Rezoning Petition Review – Charlotte Tree Ordinance

Subject: City of Charlotte – Urban Forestry Rezoning Petition Review Summary

Rezoning Petition: 2021-101

**RZ - 1.0**

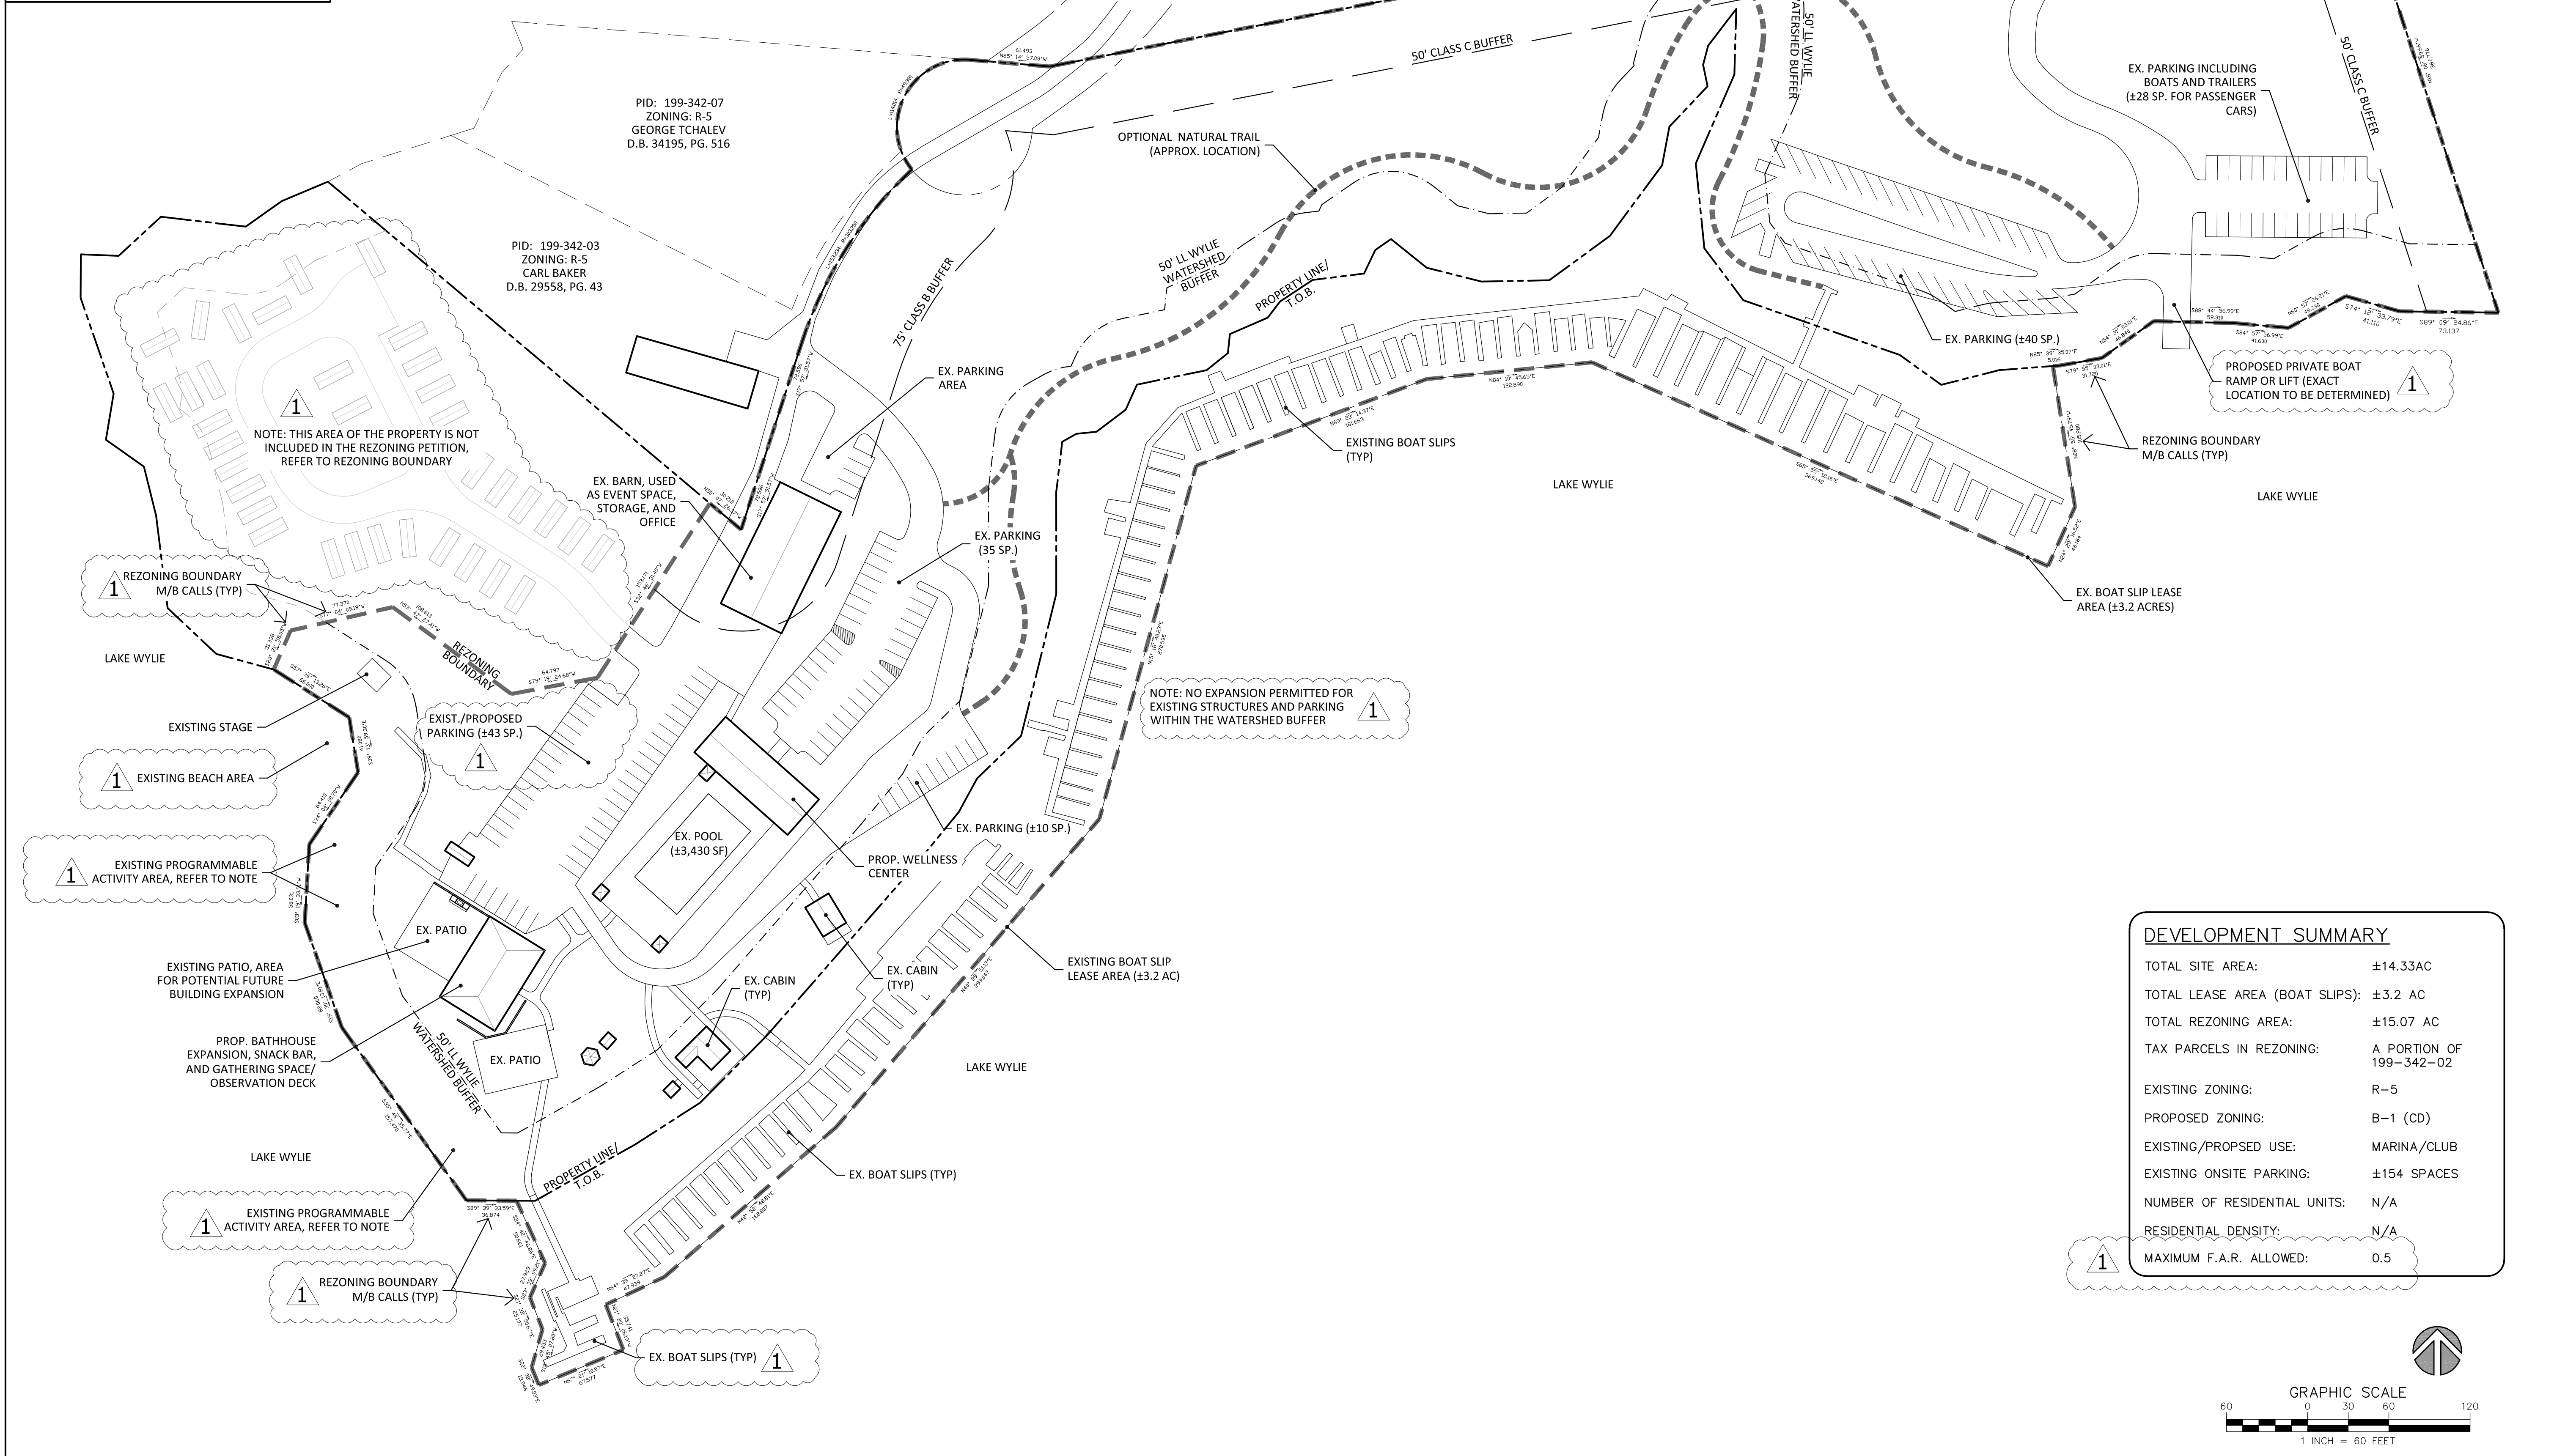
- Include the following note: *“The site will comply with the Charlotte Tree Ordinance”*

- A tree survey shall be submitted identifying all trees of eight-inch (8) dbh or greater and all planted trees of (2) two-inch caliper or greater and six feet in height that grow partially or wholly within public street right-of-way.

- Conditional rezoning petition submittals shall provide notation referencing how tree save requirements will be met by the site and depict potential tree save areas.

- Perimeter trees are required to be planted along all public roads per the Charlotte Tree Ordinance.

- Small-mature tree species are required in locations where overhead distribution lines may impact natural tree growth.
- Internal Trees: Internal trees may be required to be planted in all surface parking lots and to mitigate impacts from impervious surfaces on-site.
